RE Lismore Base Hospital Carpark Façade - Section 96

The revised design (ACD 3003, ACD 3004) retains the design intent illustrated on the DA drawings. The design has been approved by the concept architect Fitzpatrick and Partners and the client Health Infrastructure.

DRAWING NUMBER: **ACD3003** REVISION: **H**

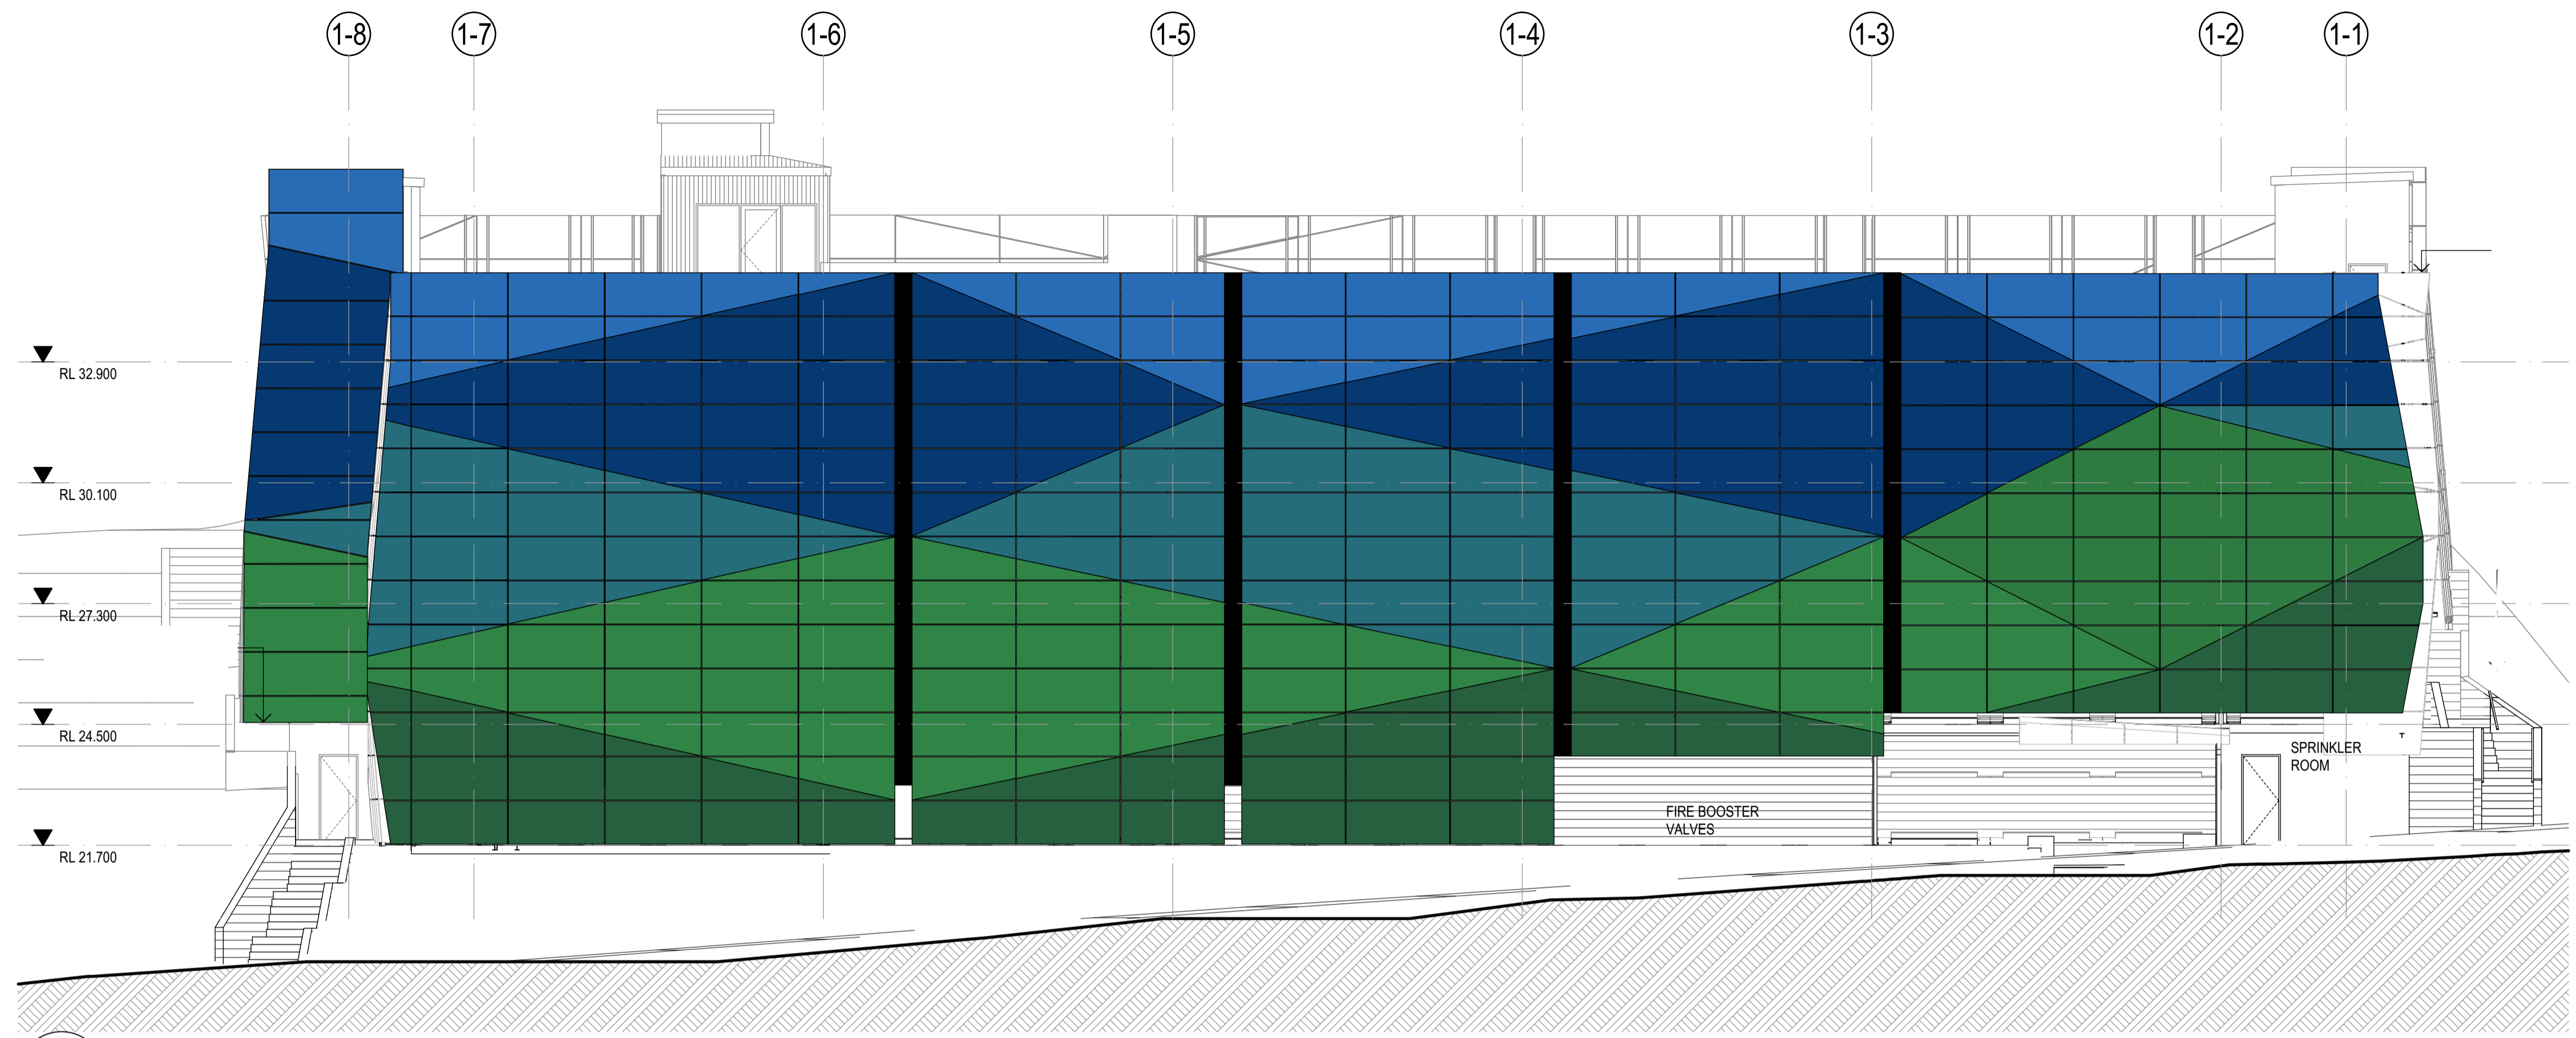
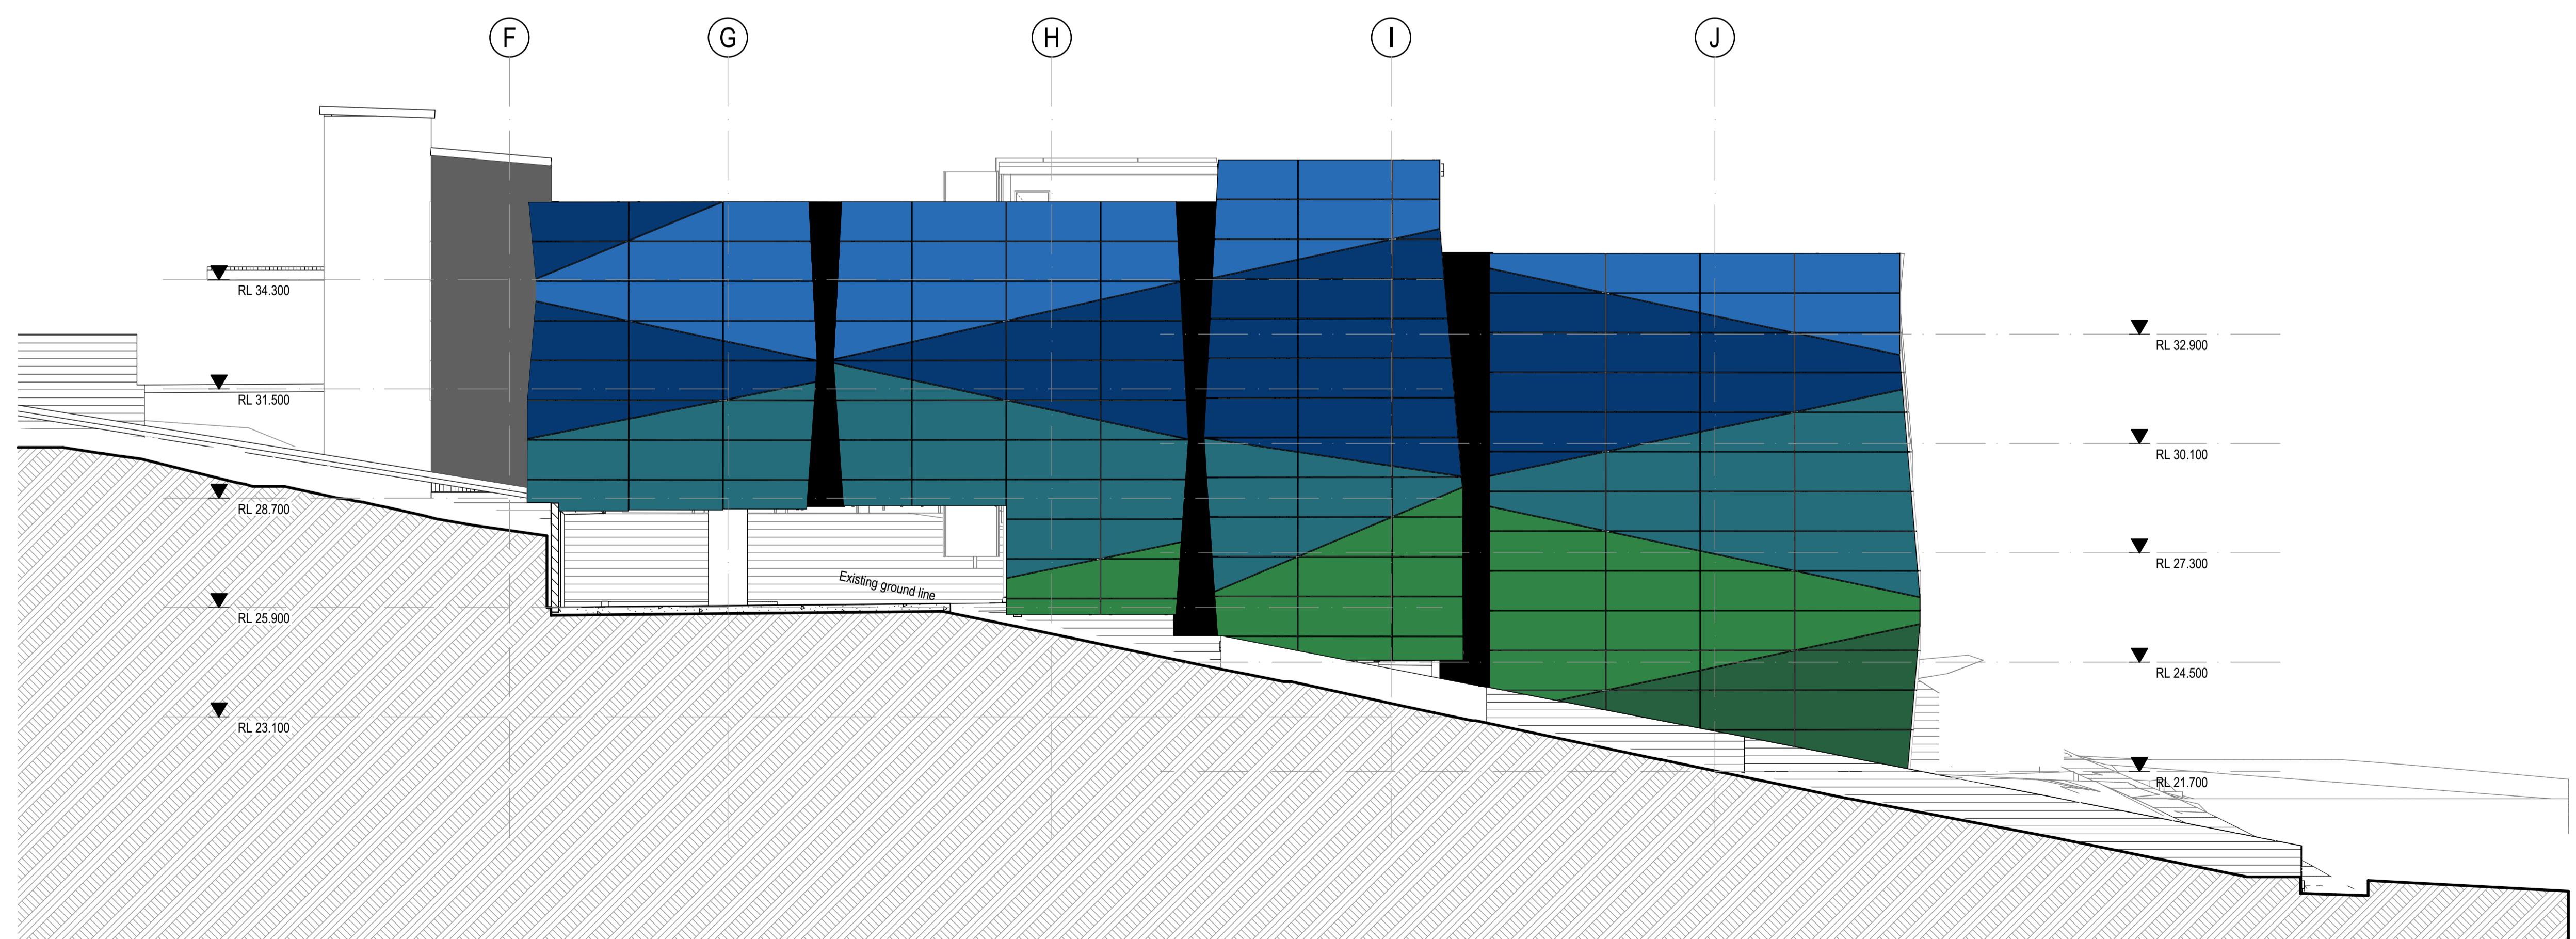
- The layout shown on A0500 Façade section and details shows panels spanning between slab – our engineers raised concerns about the material spanning 2800mm
- The were odd shapes that were not possible to fabricate
- Junctions of the screen that were not possible to fabricate
- The 9 powder coat colours specified were all custom colours – these were not available unless a minimum of 300m² was ordered – most were less than 300m²
- Because of the sloping site and proximity to the boundary installation of the screen could not happen from scaffolding – the screens needed to be lowered from above

- Maintained the blue green palette – 5 powder coat colours
 - Maintained the black perforated gutters that divide the faced into vessels
 - Maintained the height and general extent of the screen
- The only significant change in scope is the addition of coloured façade to the north elevation. This was shown as chain wire on the DA drawings
- Maintained the faceted arrangement of the colours and random arrangement of these facets
